**EIS - First Building Bradfield City Centre (SSD-25452459)**

## TAB A – REQUEST FOR ADDITIONAL INFORMATION

GENERAL ARRANGEMENT PLAN

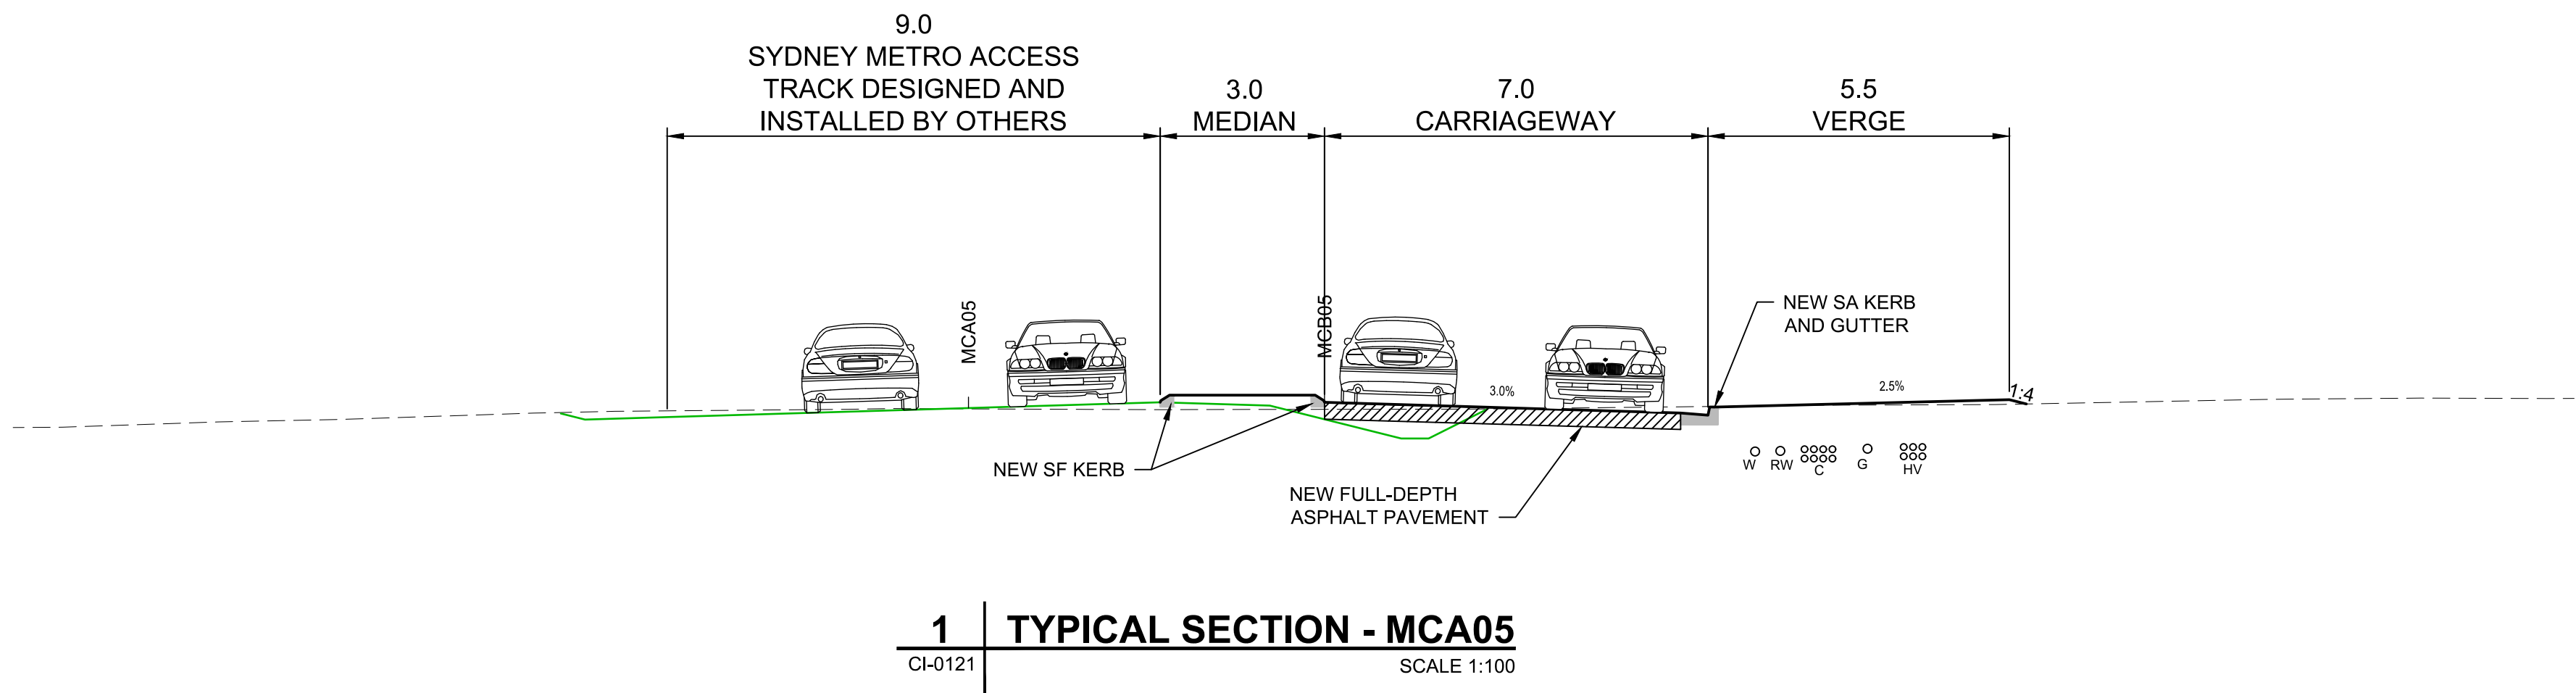
The site boundary in the civil engineering plans appear to show a slight encroachment of proposed works into the agreed Sydney Metro construction site area as indicated in the EIS for the Metro project. Further work is currently being undertaken by Sydney Metro that may result in a refined boundary of the Metro works.

Sydney Metro will continue to work with the Applicant to better understand the construction site requirements and interfaces with the subject development.
